Barnhill SHD

Stage 1 Road Safety Audit

<b>Document Ref:</b>	<b>P22-091-RSA-PD-RP-001</b>
----------------------	------------------------------

Drawing file: 11. STATION QUARTER SOUTH / STATION Q SOUTH-PROPOSED SITE LAYOUT PLAN.pdf

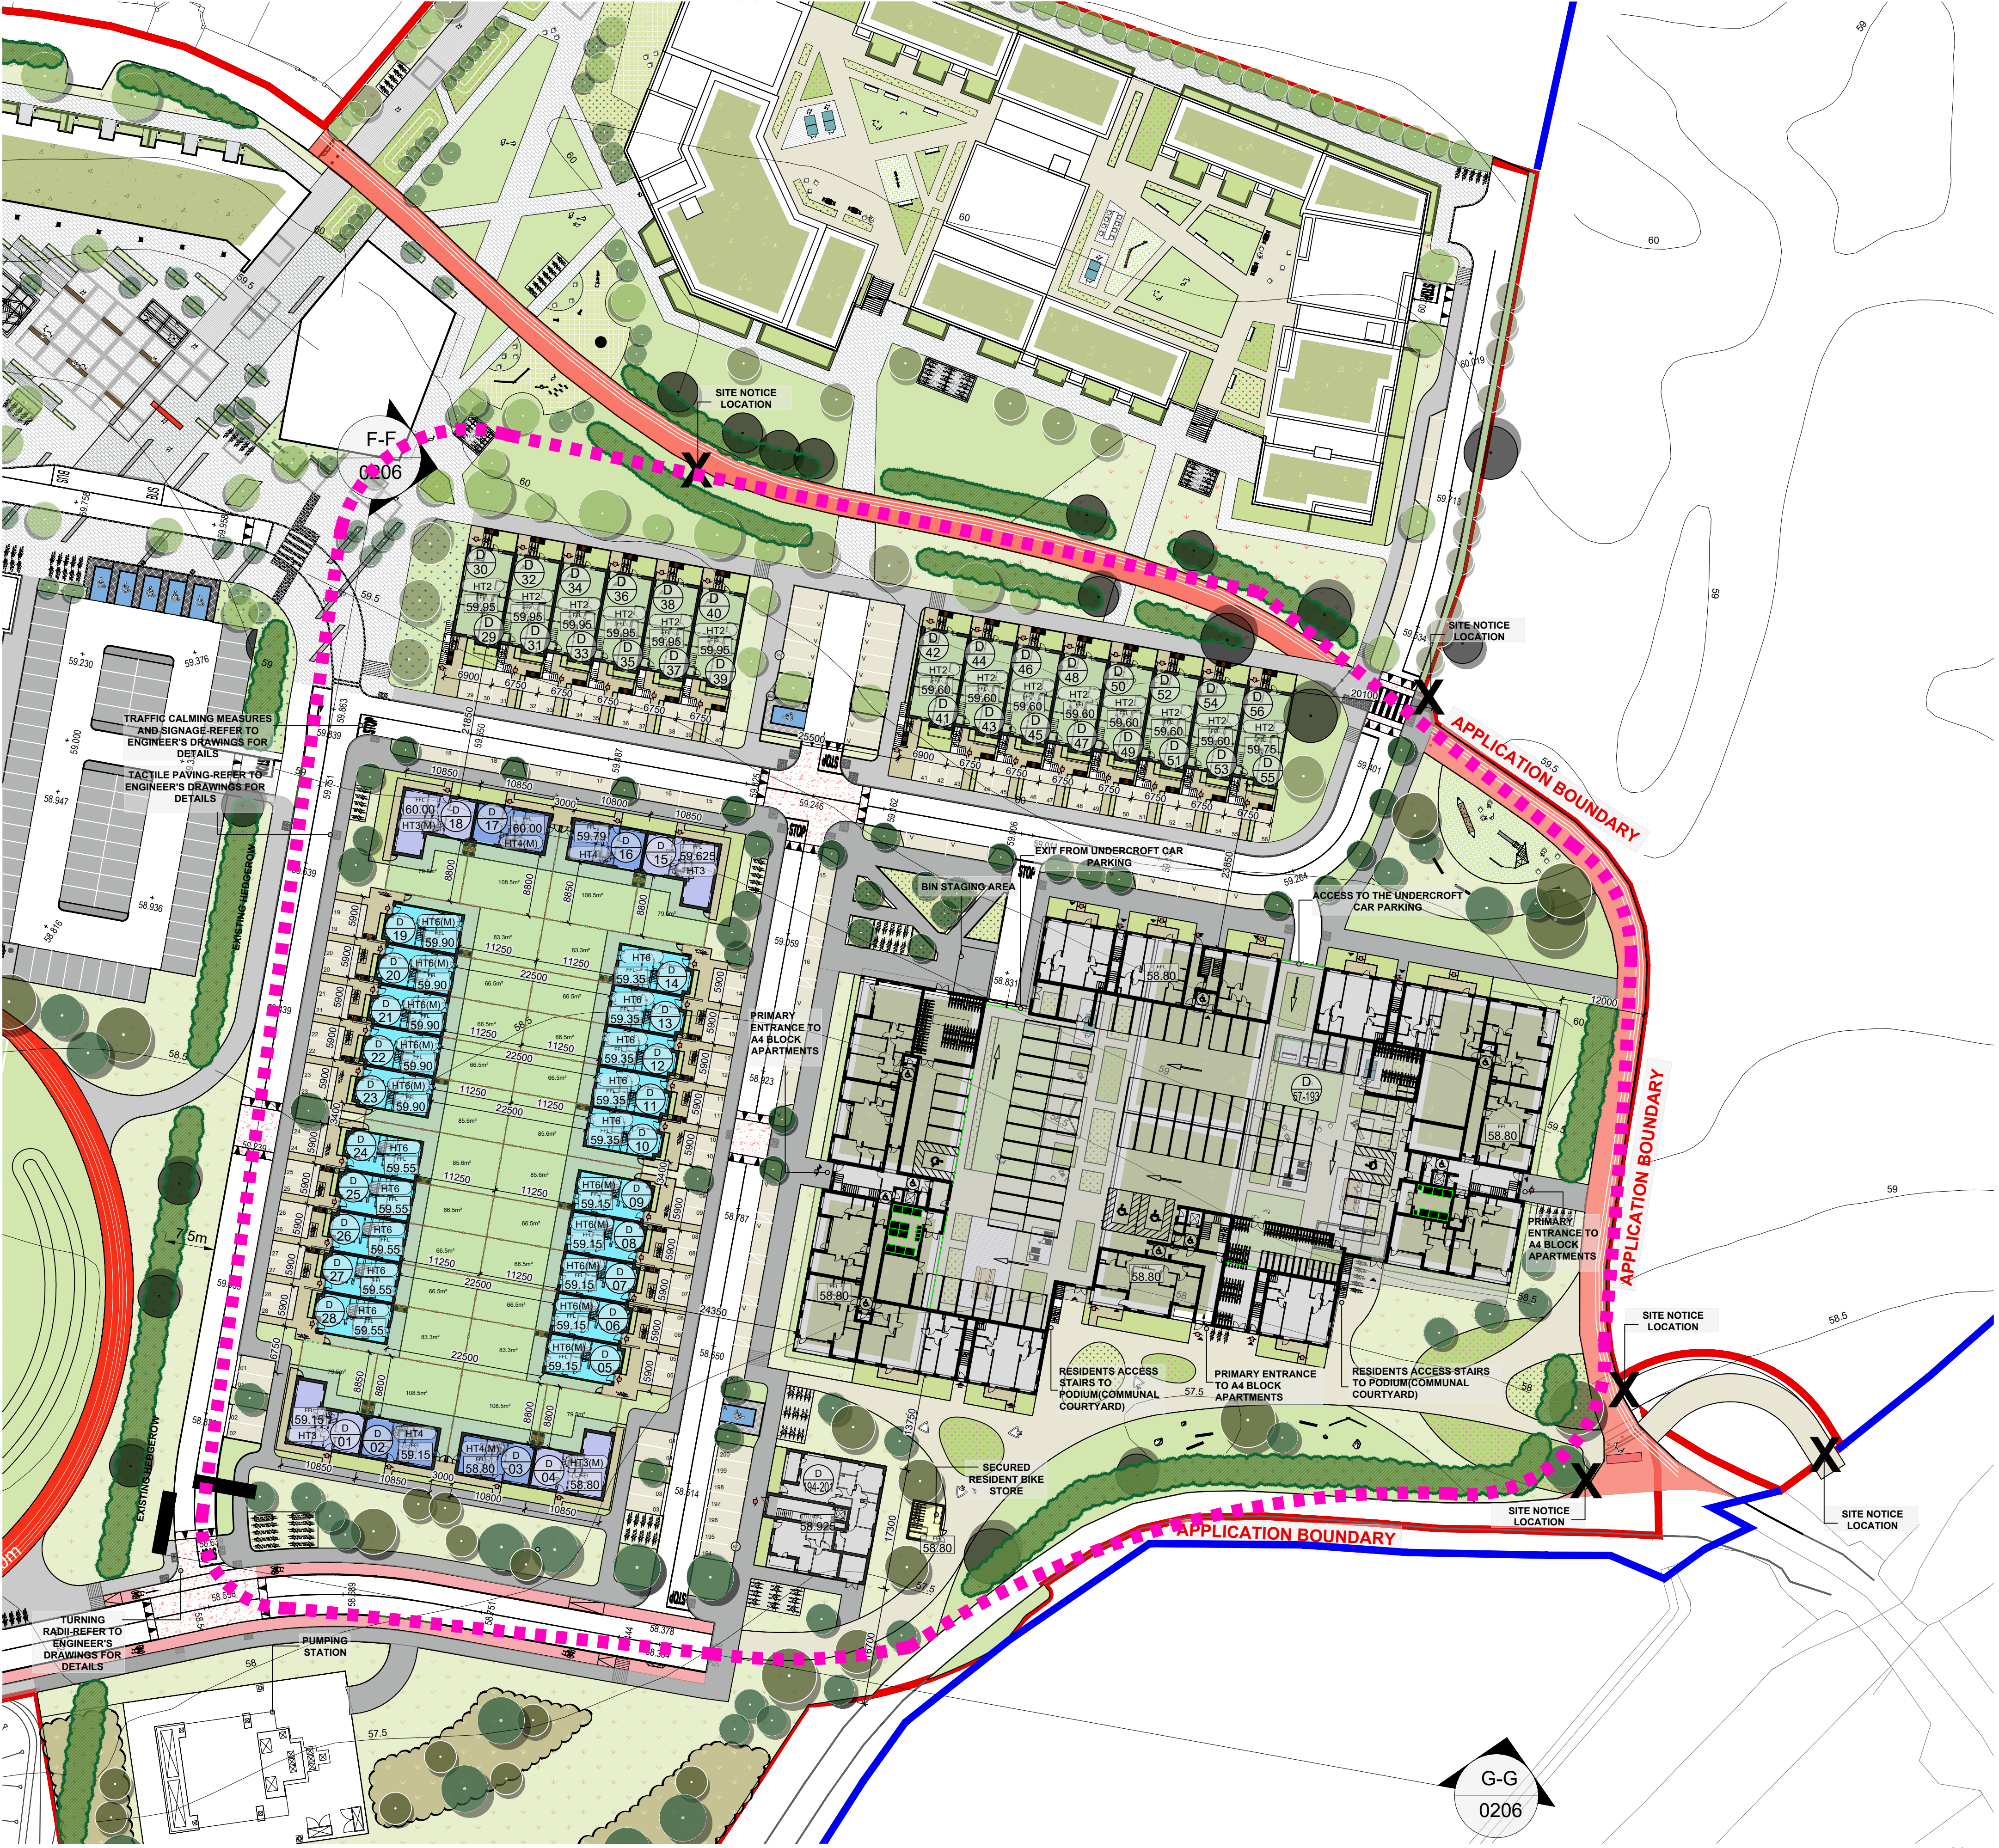
*Location: Station Area South*

*Summary: Restricted turning manoeuvres within undercroft parking spaces may lead to low-speed material damage collisions.*

The “Station Area South” under-croft carpark includes a number of parking spaces which may be difficult to exit, including parking spaces 35, 36, 53 & 11. The constrained nature of these parking spaces may lead to material damage collisions.

*Summary: Limited visibility within proposed undercroft parking may result in unsafe exiting manoeuvres.*

Visibility for drivers reversing out of undercroft car parking space 11 may be limited by the adjacent wall, resulting in unsafe exiting manoeuvres and possible shunt-type collisions.

A swept-path analysis should be undertaken to confirm safe entry/exit from the proposed car parking spaces. Where necessary, the layout should be revised to ensure that safe access/egress can be achieved from all proposed parking spaces.

Adequate inter-visibility should be provided between drivers of vehicles exiting from all of the proposed undercroft car parking spaces and approaching drivers on the aisles.

Client	ALANNA HOMES AND ALCOVE IRELAND FOUR LIMITED		
Project	BARNHILL GARDEN VILLAGE STRATEGIC HOUSING DEVELOPMENT (SHD)		
Dwg. Title	PROPOSED PARKING, EV, BUS STOP AND LOADING BAY LOCATIONS		
Drawn By	KF	Date	JULY 2022
Checked by	CDR	Scale	1:2000 @ A1
Dwg. Progress	PLANNING		
Dwg. No.	16_053_009

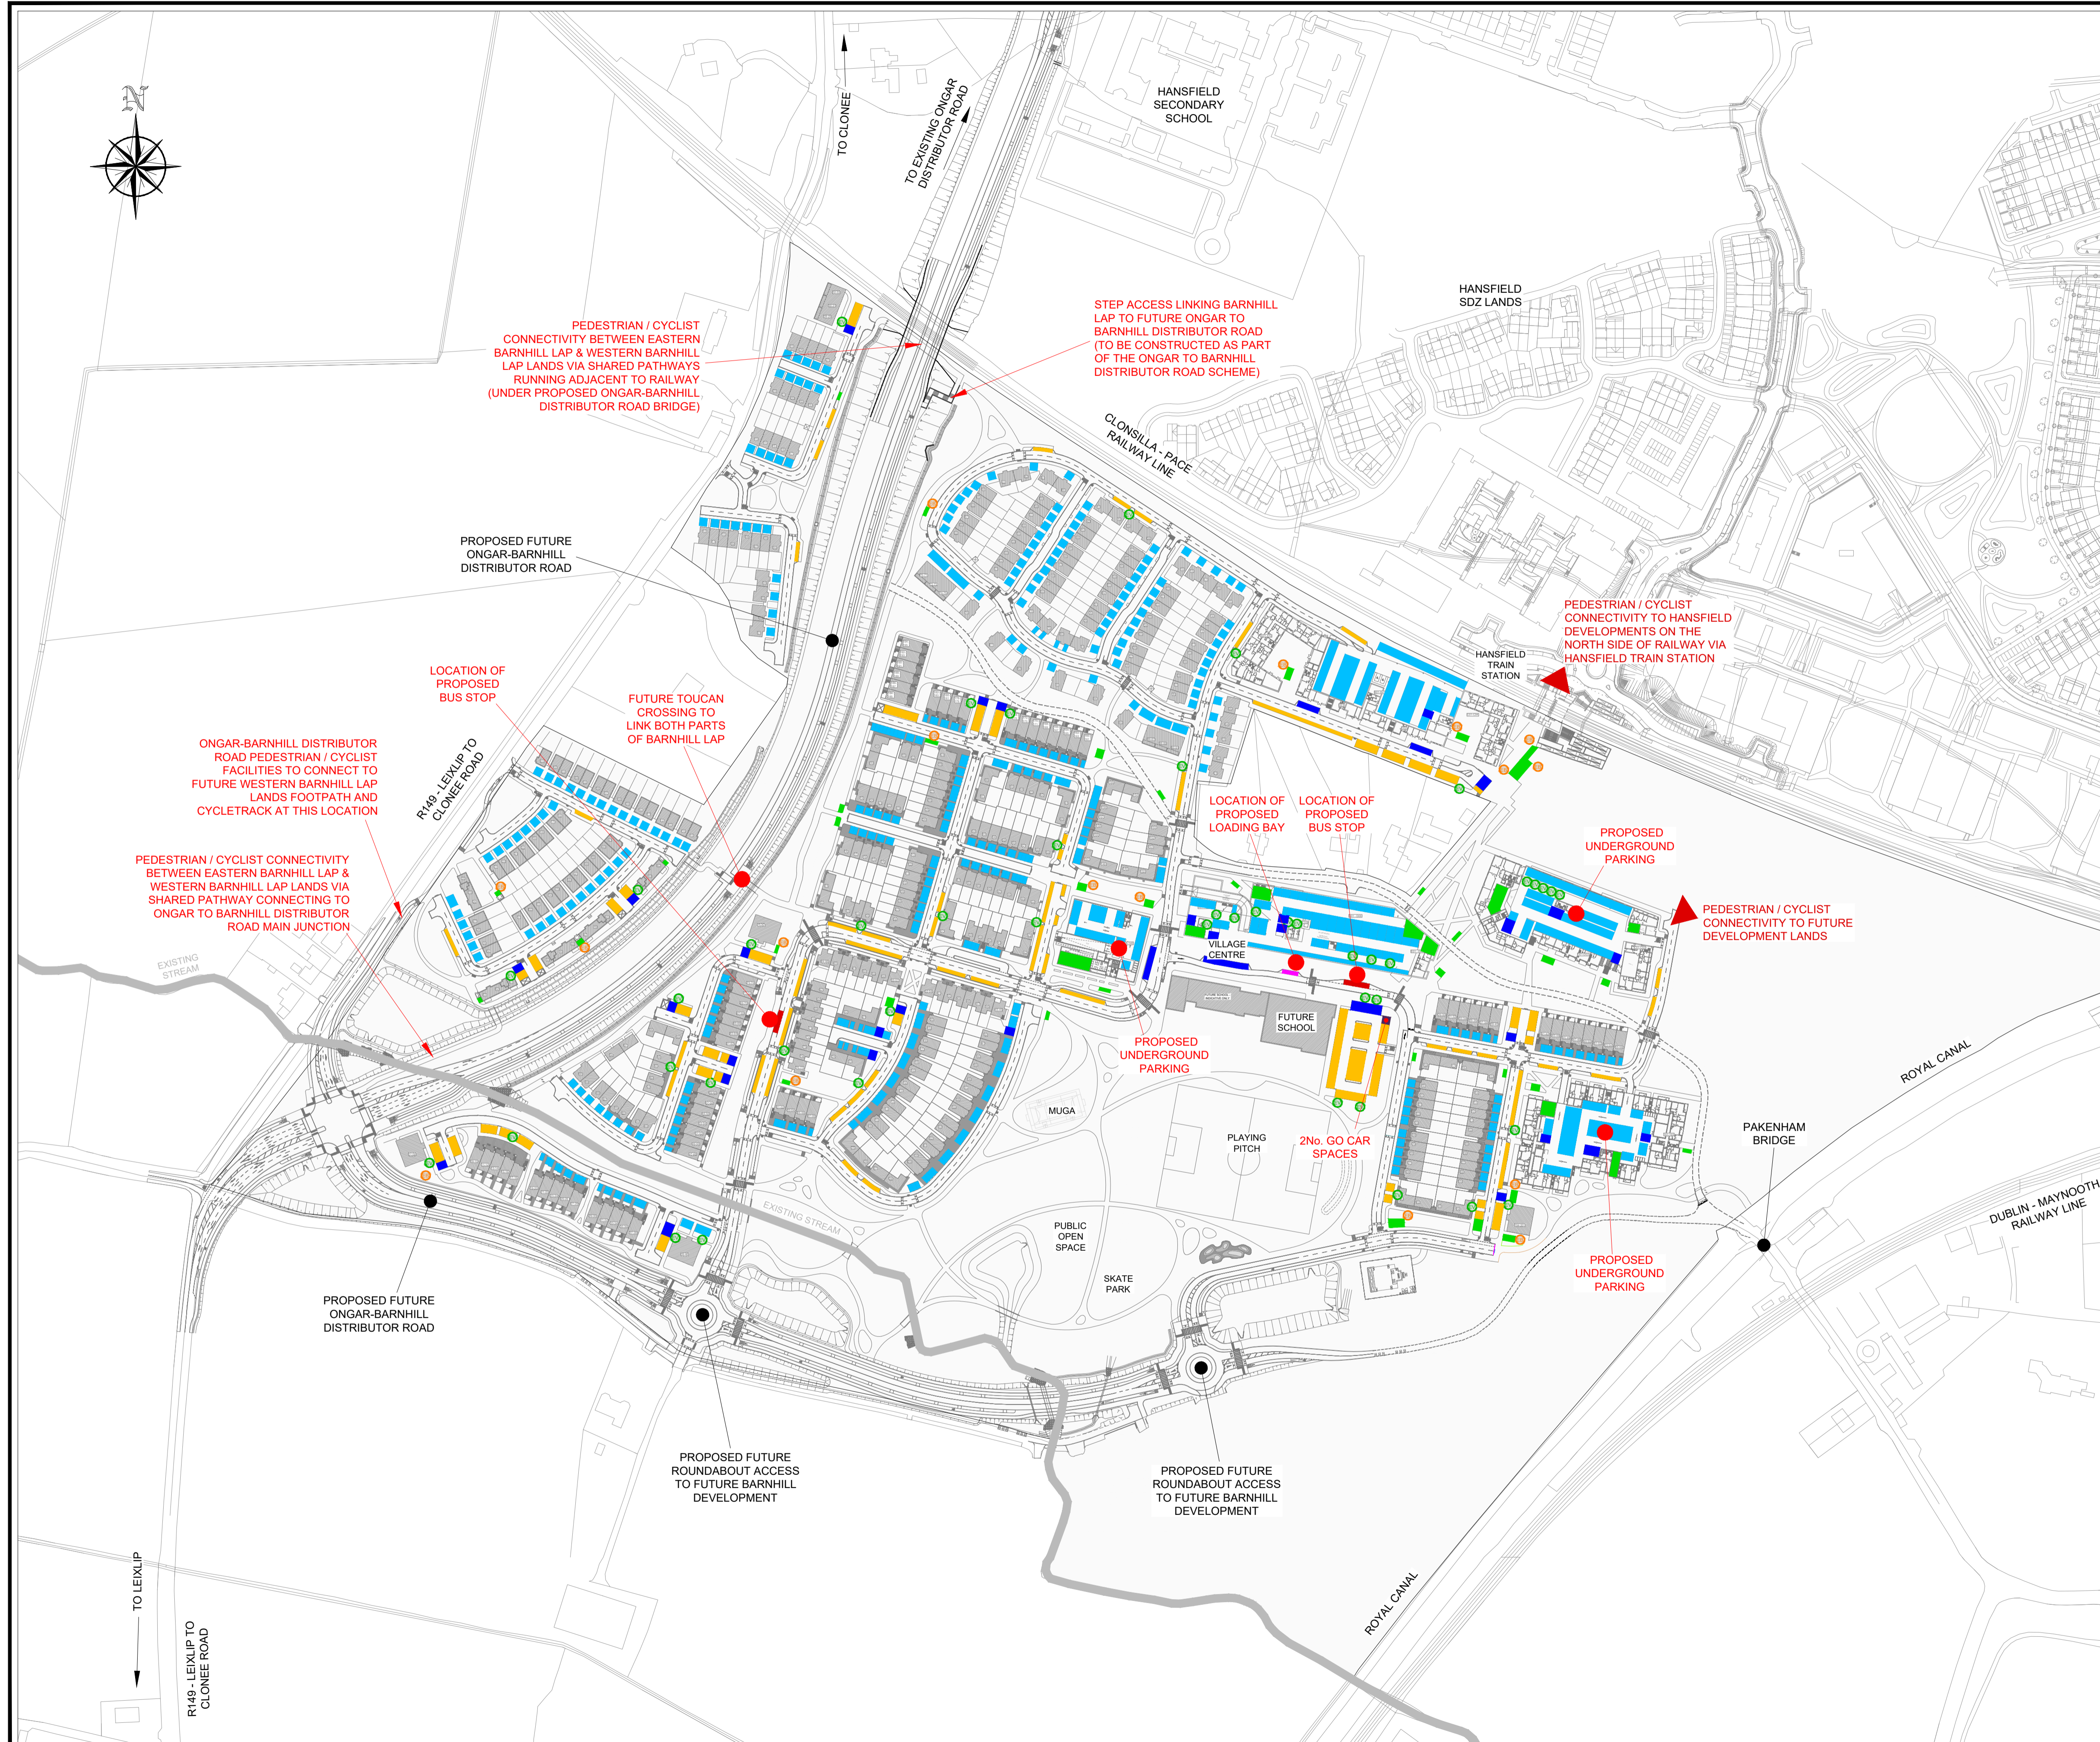
- 4.4 Electric Vehicle charging points have been indicated adjacent to a number of the parking spaces proposed, predominantly at perpendicular parking spaces which are adjacent to mobility-impaired parking spaces, which have a buffer around them, or within buildouts at parallel parking locations. Public EV parking spaces should be sized in accordance with Chapter 7 of the Traffic Signs Manual.
